Epping to Thornleigh Third Track Proposal. Application number SSI 5132.

~~We~~ We object to the Epping to Thornleigh Third Track Proposal and consider that the EIS is inadequate and does not address the full impact of this proposal. It will cause untold damage to the health of residents and to the fabric of the Beecroft Cheltenham Heritage Conservation Area. Do not approve this project, reconsider the alternatives and protect the community.

Figure 5.6 Cross-section and elevation - New Cheltenham Station concourse building
Note: Indicatively added to future design

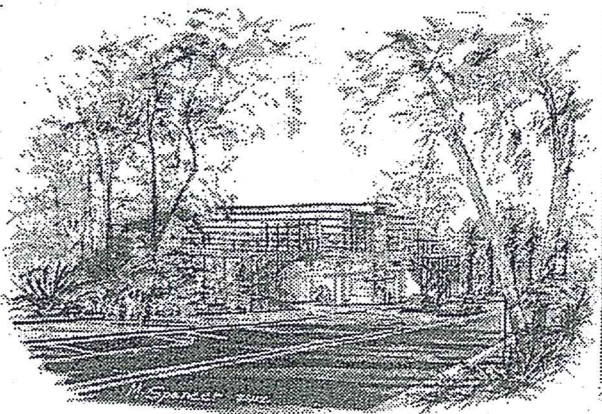
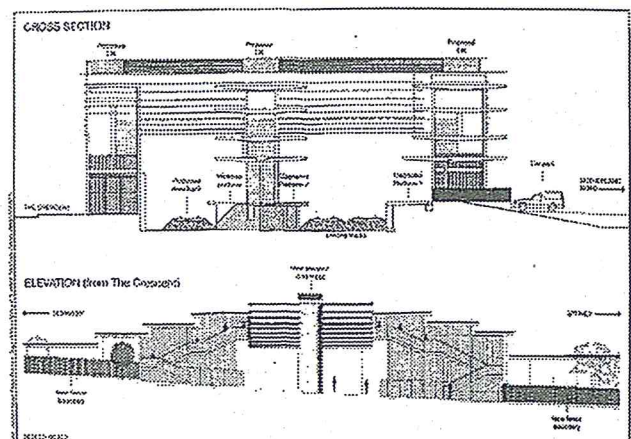
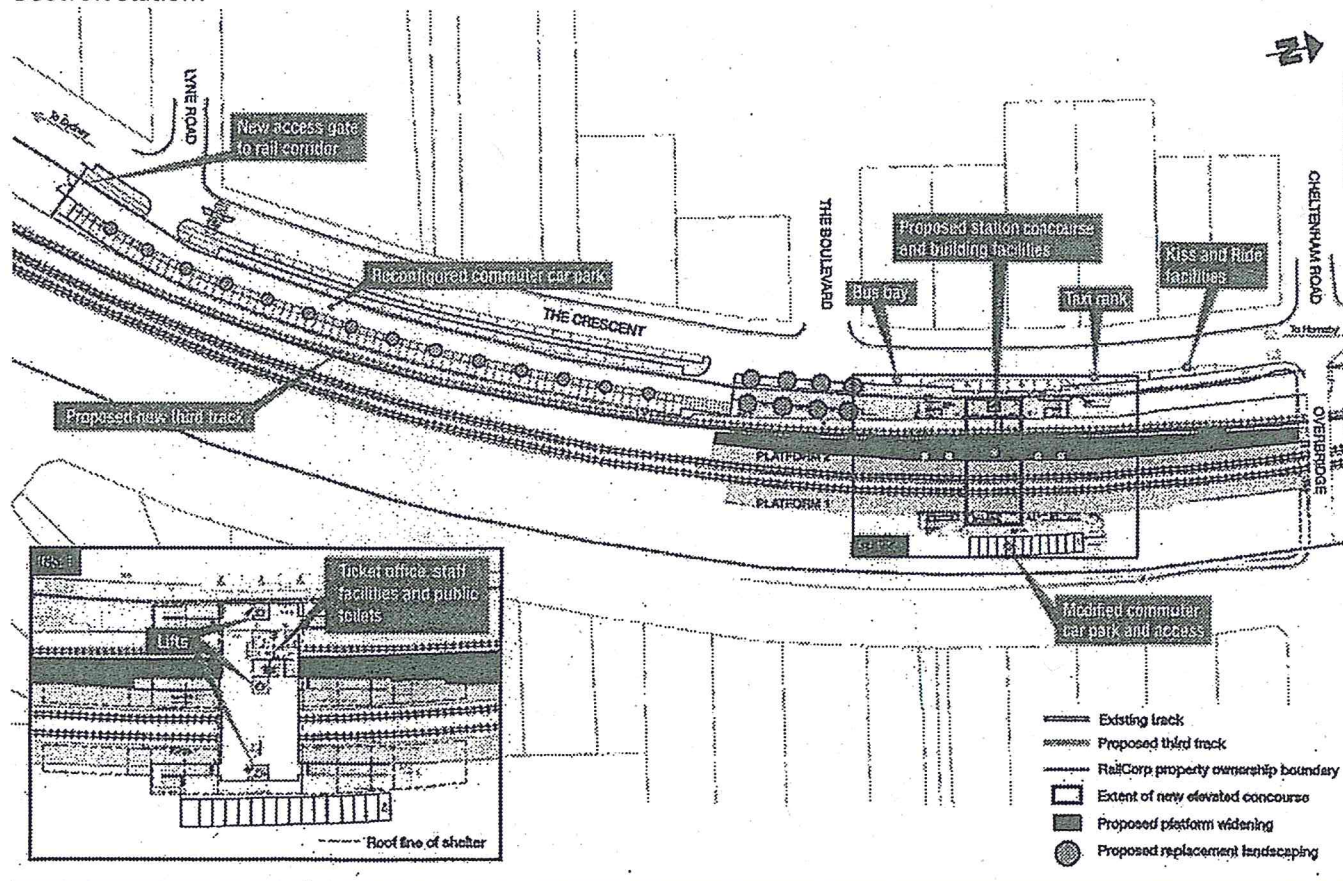
- The proposed redevelopment of Cheltenham Station shows no regard for the HCA. The visual impact of the proposed 13m high glass and steel concourse is totally unacceptable in this HCA.

Concept design drawing of proposed changes to Beecroft Station (Parsons Brinckerhoff 9/3/12). Former side platform shaded in pink.

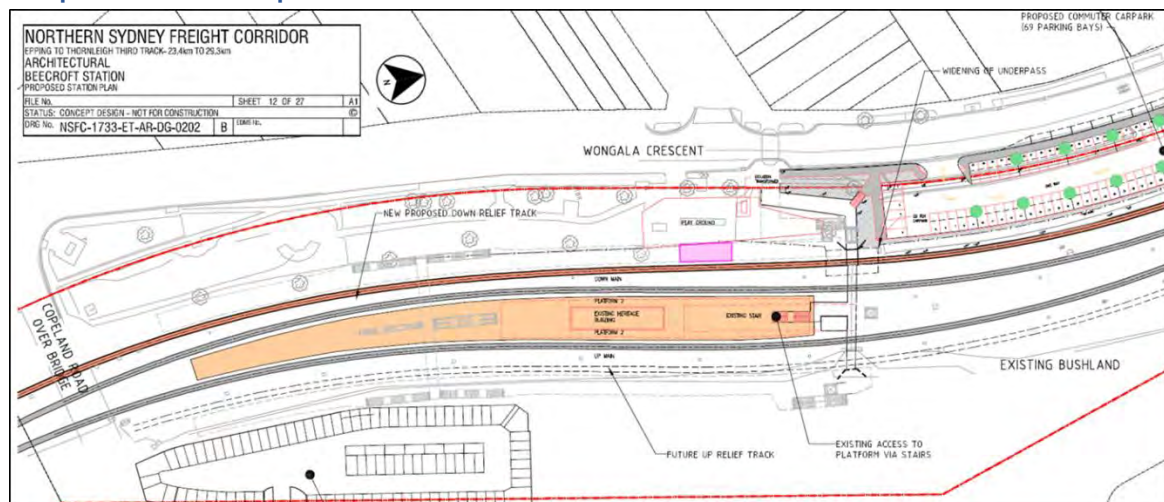
- There has been inadequate assessment of the project's impact on the fabric of the Beecroft Cheltenham Heritage Conservation Area (HCA).
- The plan given for Beecroft Railway station Precinct is vague. The relationship to the trees, playground and original 1895 platform located south of the present station is not shown. A fourth track is shown on the eastern side. The plan does not include urgently needed lifts to allow disabled access at Beecroft Station.
